DOC21/1022911-7

20 December 2021

**Eraring Battery Energy Storage System (SSD 15920052)
Advice on Environmental Impact Statement (EIS)**

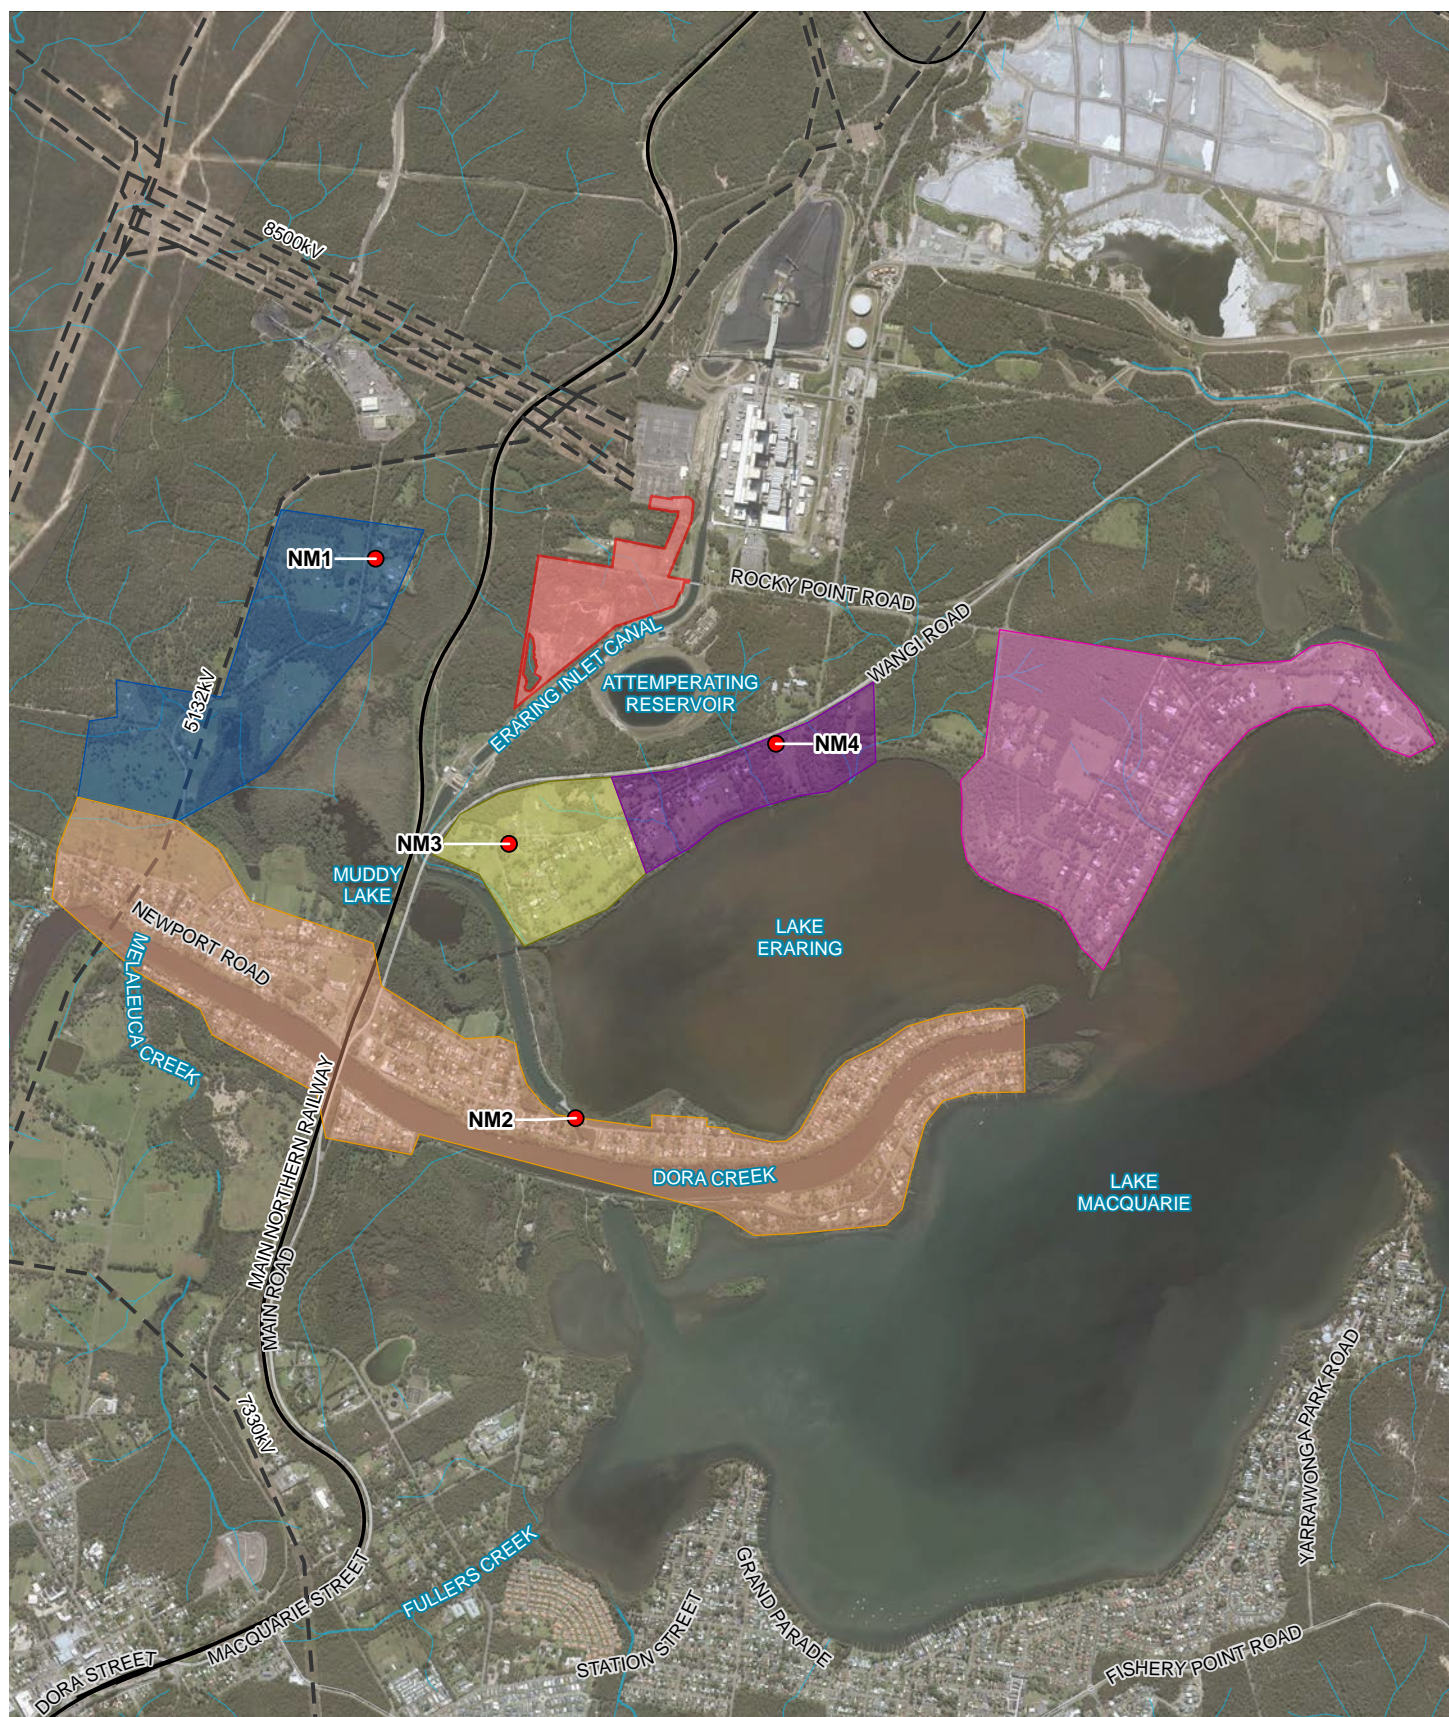
- Background noise monitoring was not undertaken in NCA5 and the levels for NCA3 have been adopted for NCA5 in the assessment. NCA5 is further removed from what are described as significant regional noise sources such as Wangi Road, the Main Northern Railway and the Eraring Power Station. There is insufficient justification to accept the noise monitoring results for NCA3 as being representative of NCA5.

Table 5.6: Receivers used to Predict Noise Impacts

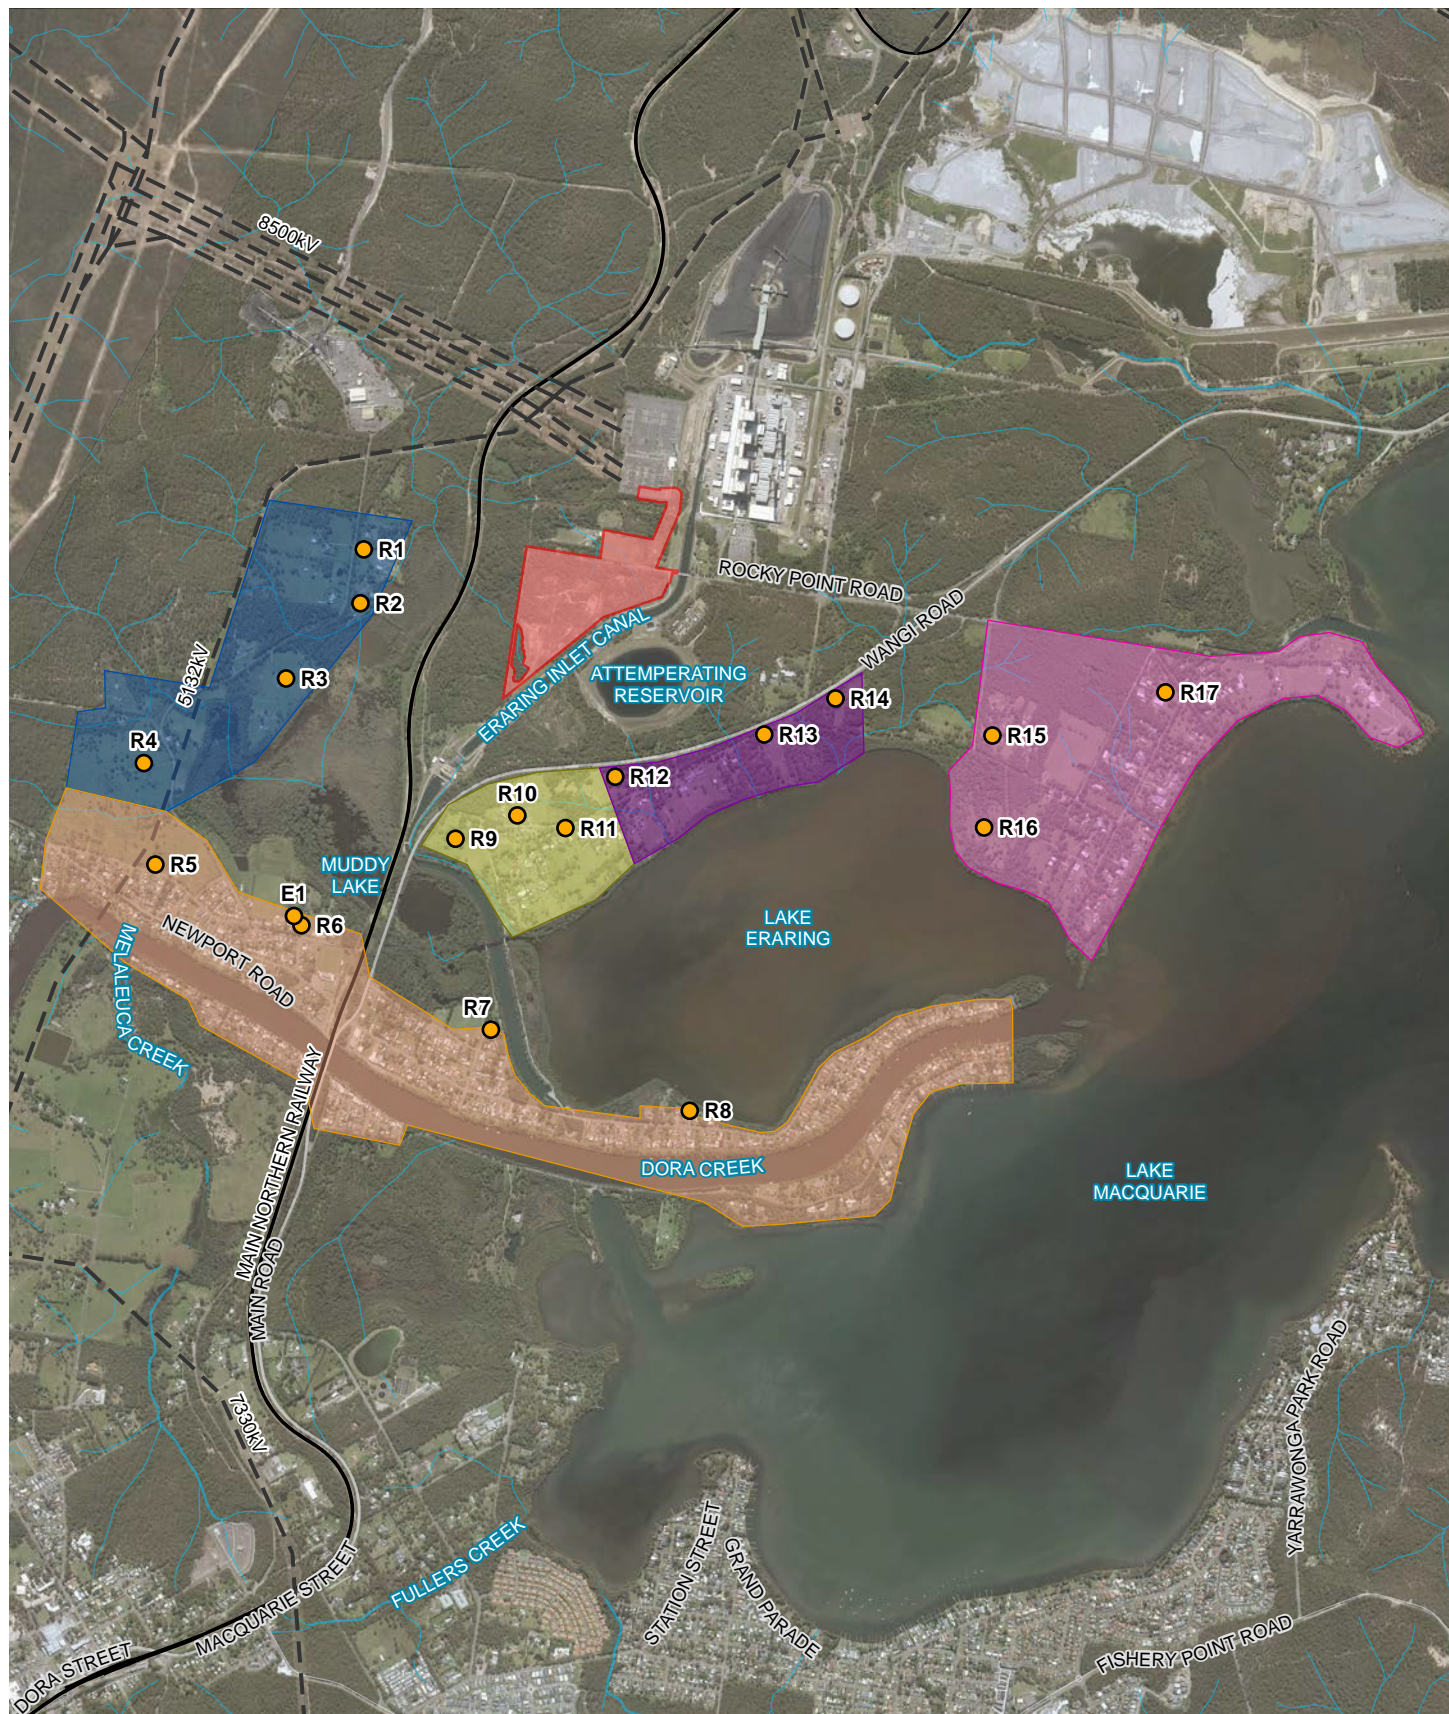
- The NIA at Section 7.2.2 suggests that the modelling has not considered the potentially worst affected receivers in NCA3. The proponent should confirm that the worst affected receiver locations for each NCA have been considered and presented in the NIA i.e. “*Table 5.6: Receivers used to Predict Noise Impacts*”.
